Elizabeth Elenius, Convenor
9C/2 Bowman Street
PYRMONT NSW 2009
Tel: 9571 9727; 0409 552 117
Email: eeelenius@bigpond.net.au
www.pyrmontaction.org.au

SSD 6011 – The Haymarket, North West Plot – commercial/office

We wish to make the following comments on the DA for the above development.

SIGHT LINES AND VT PLAN 1:2500 @A1

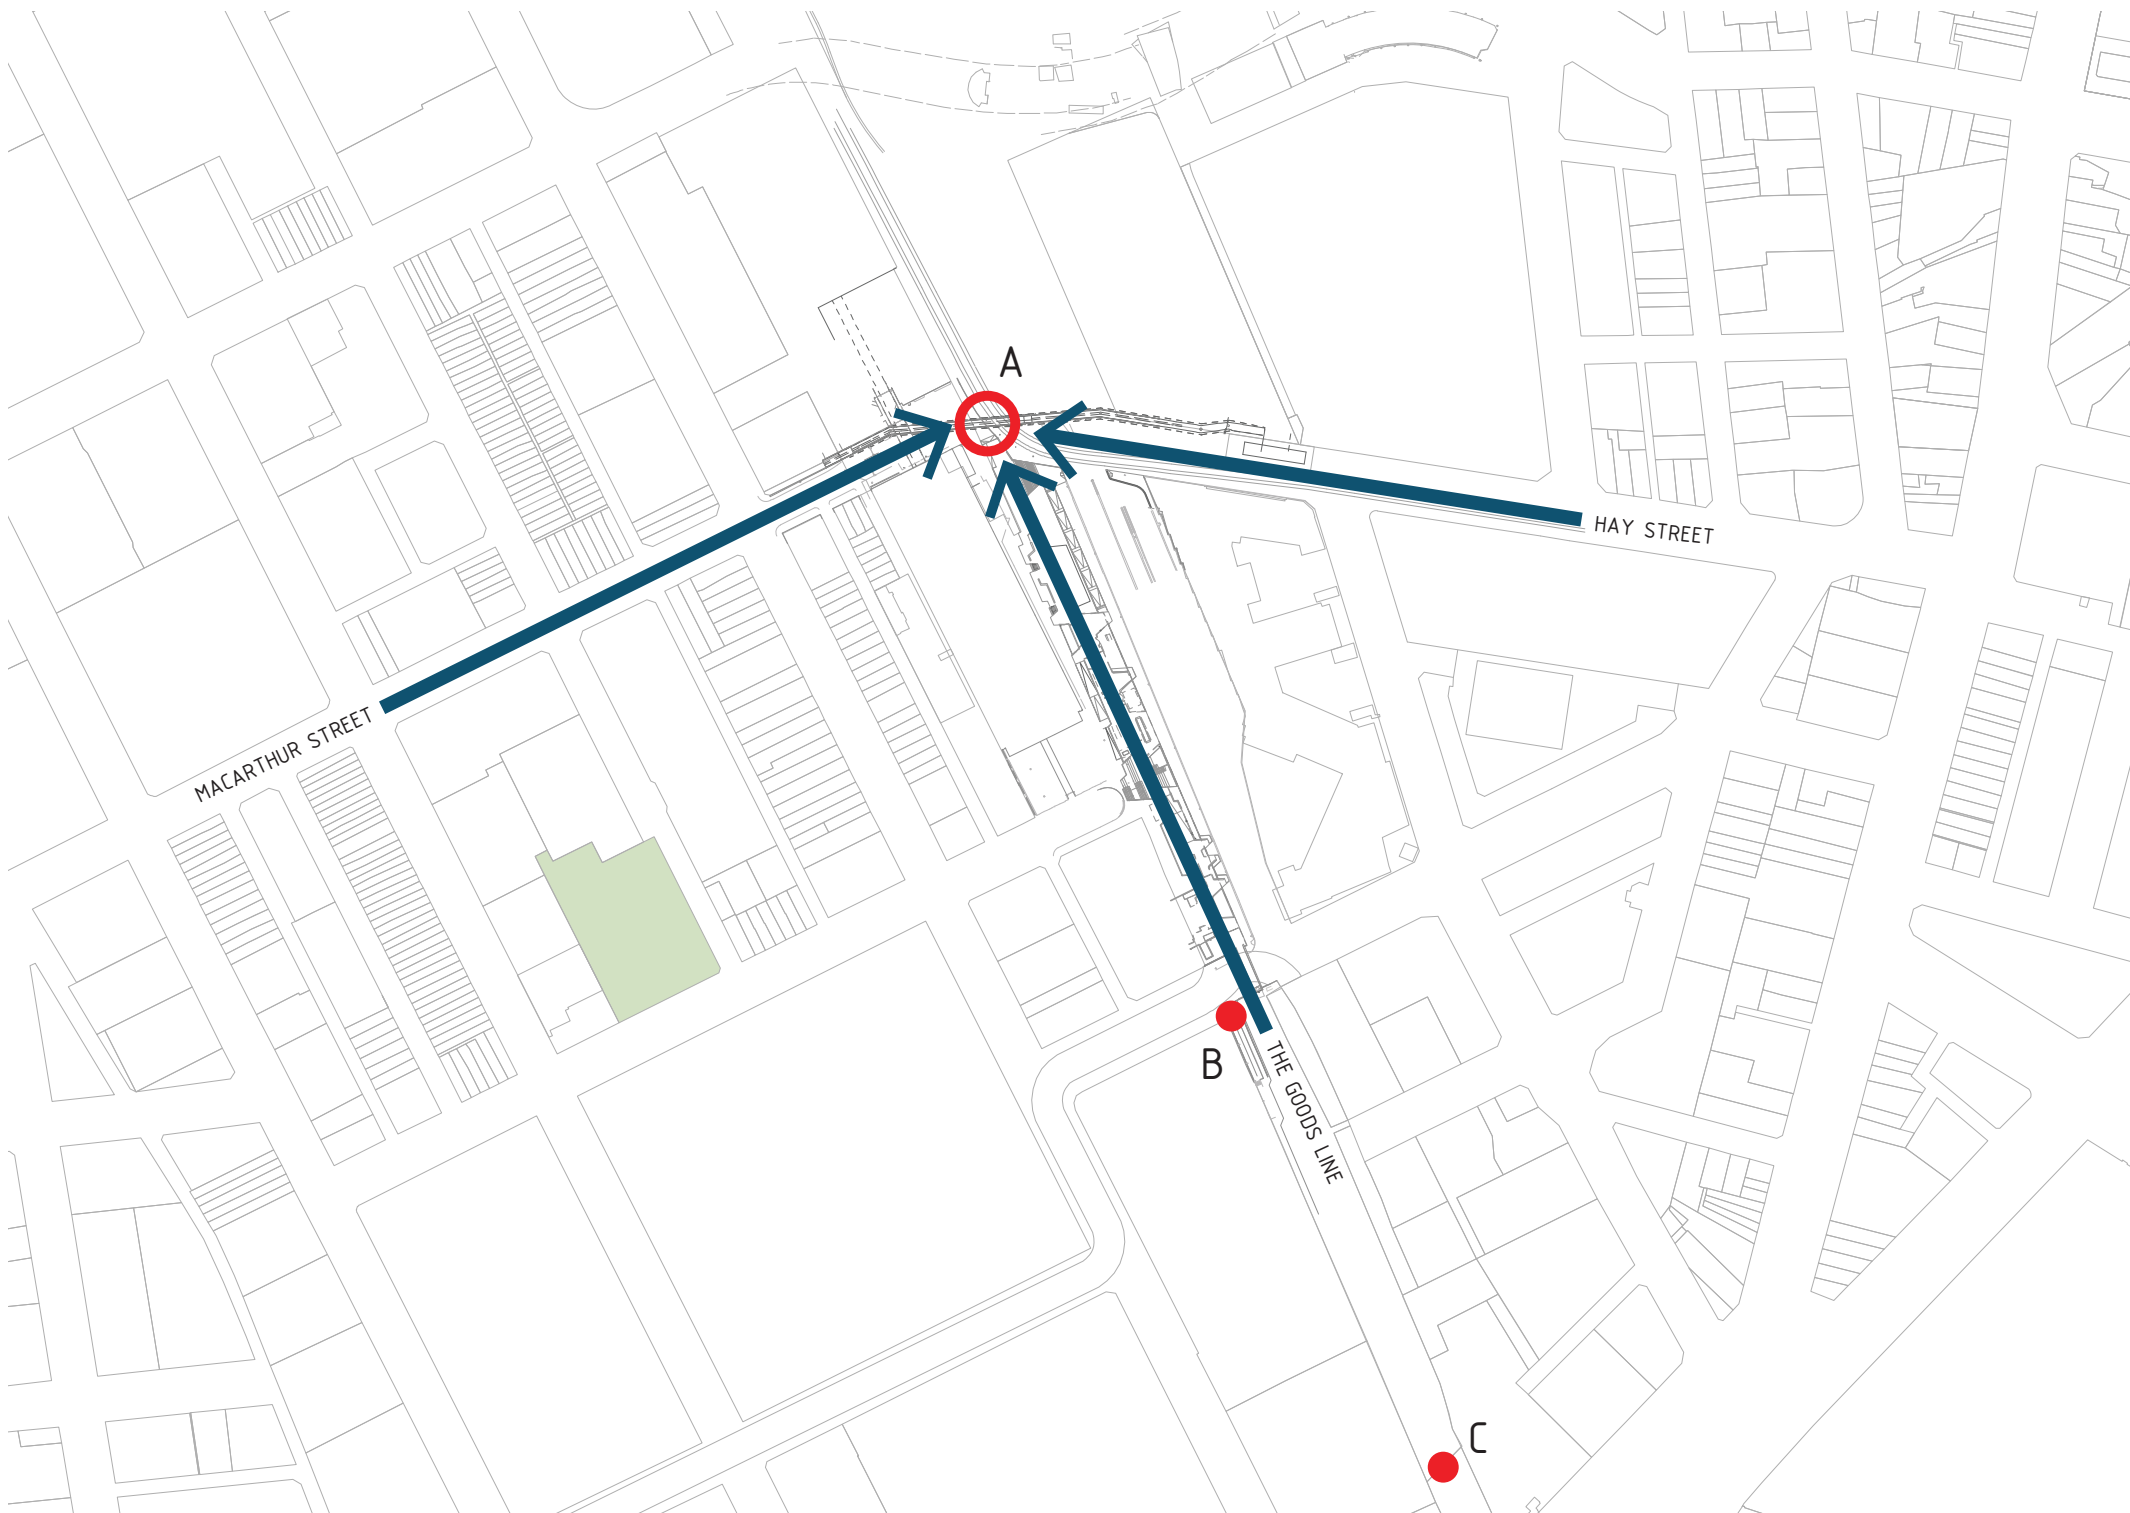
- 1.0 Access – We note that one of the objectives of the Haymarket developments is improved access to Ultimo (p9 EIS). Clearly, with the removal of the Macarthur St walkway and the provision of an unsatisfactory alternative accessway involving the need to drop down to Darling Drive and then zigzag through the site, this objective has not been met. This is an important accessway to the only bus service (501) currently available to serve the precinct, with a stop just outside the Powerhouse Museum. It should also provide a convenient, and direct link to Ultimo, UTS and SIT, but, as currently configured, doesn't.

Recommendation: That a direct pedestrian/cycle link be provided from Harris Street into the Haymarket Precinct in place of the circuitous link outlined in the DA. This link must also provide for the disabled and people with strollers.

INDICATIVE PLANT IMAGES

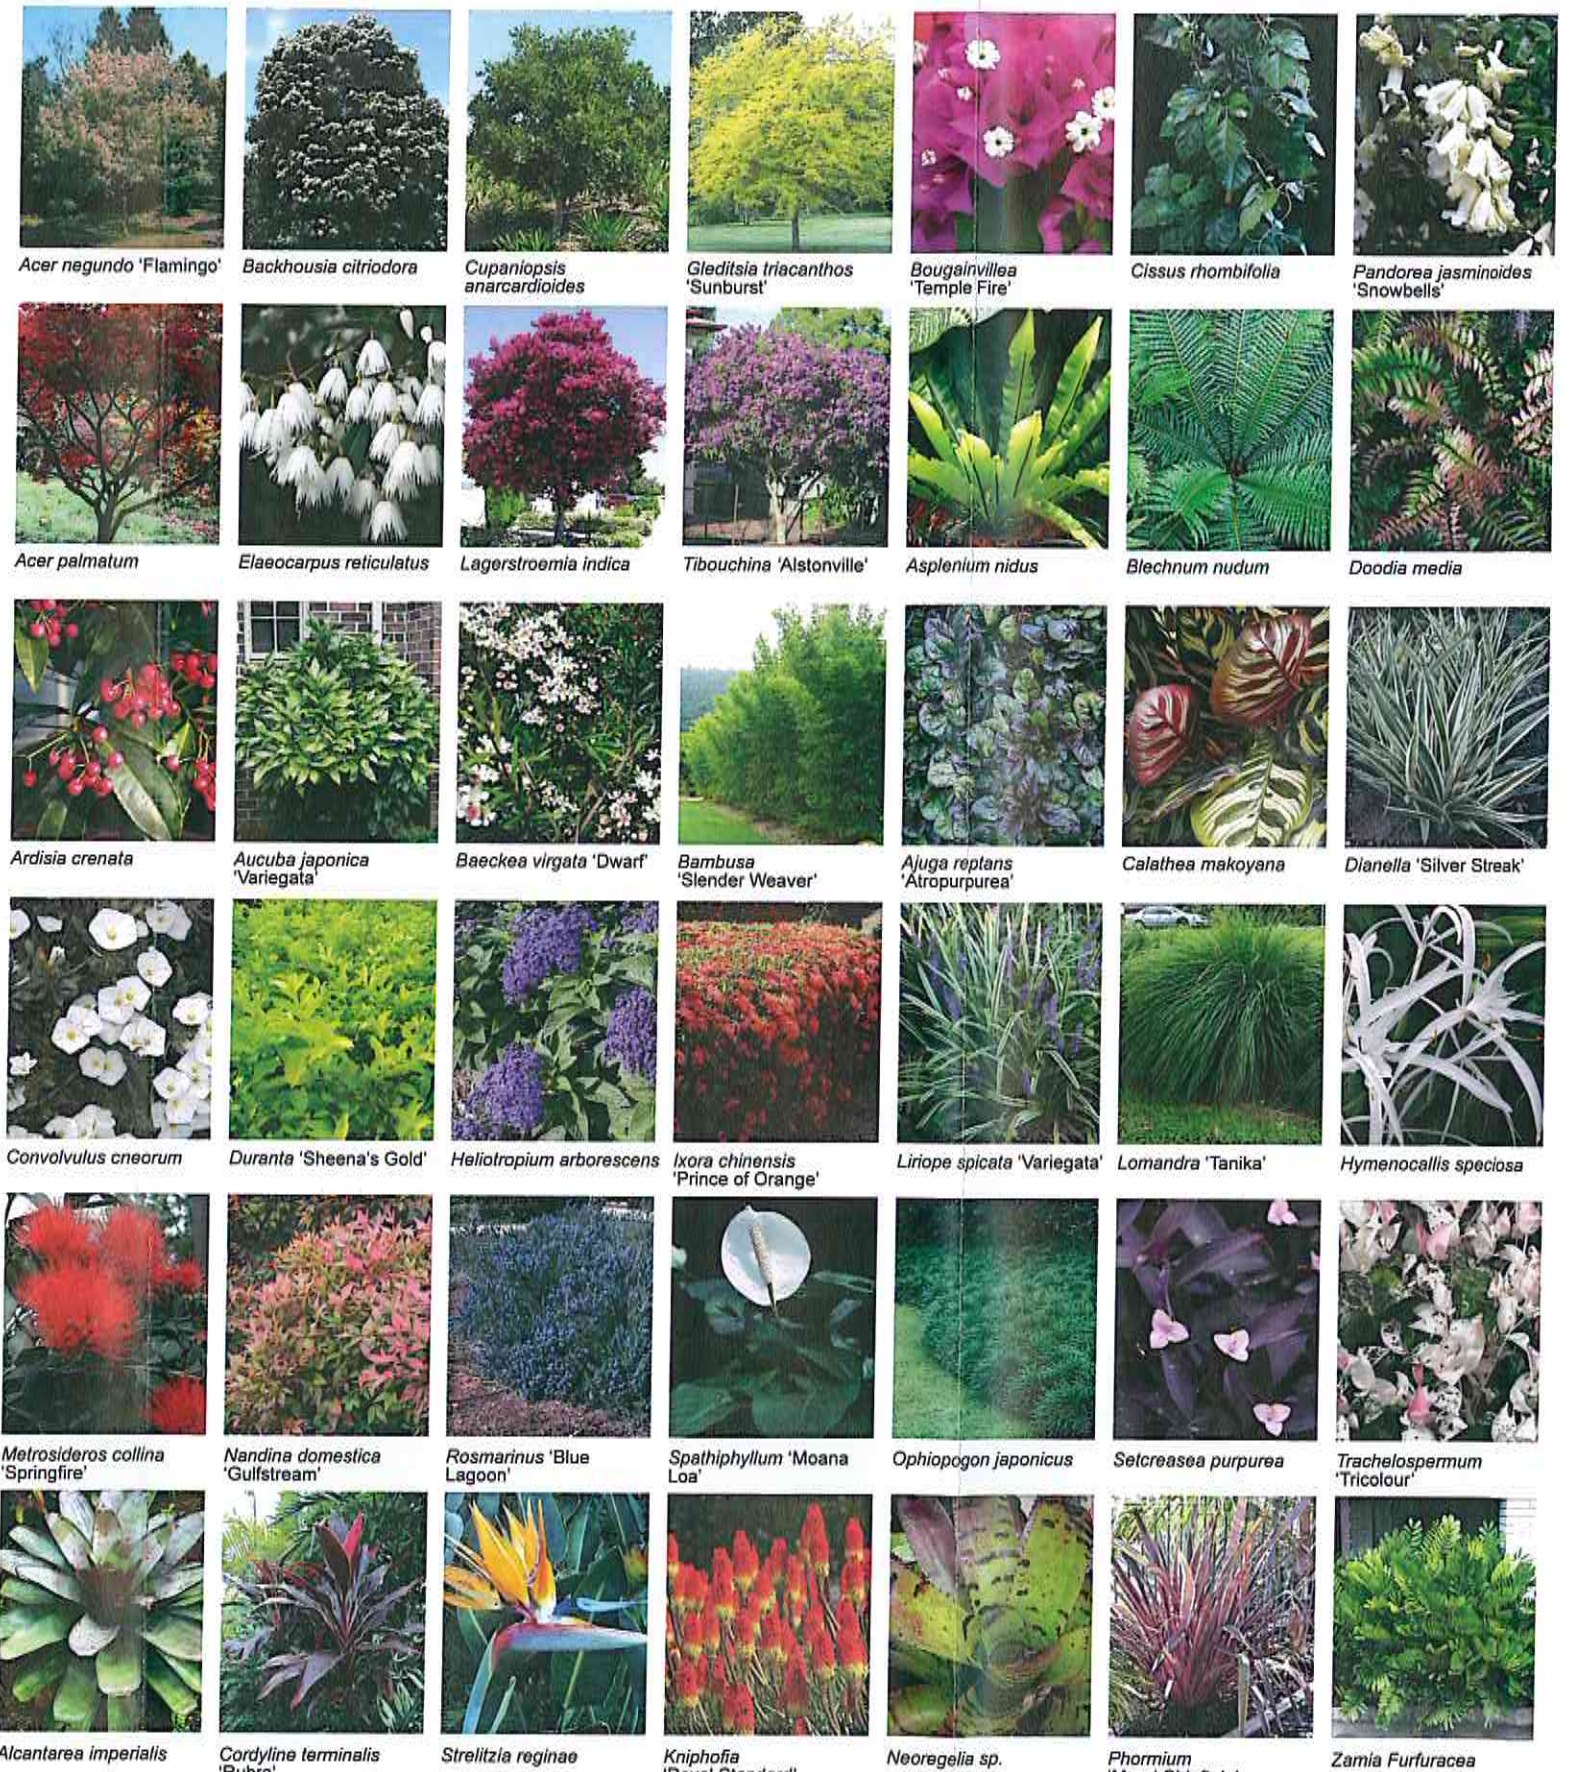
- 4.0 Landscaping – We note that there is a preponderance of exotic trees and shrubs proposed for the landscaping of the Haymarket precincts. We further note that virtually all existing trees within Darling Harbour to the West of Tumbalong Park will be removed, including the stand of mature ironbark eucalypts. This development should celebrate Sydney harbour's indigenous flora and not try to emulate European cities by planting exotic species. We support installation of community gardens in the precinct.

Recommendation: The landscaping for Darling Harbour and the Haymarket precinct should celebrate the local indigenous flora and not include exotic species. Opportunities should be provided for residents to participate in community gardens.
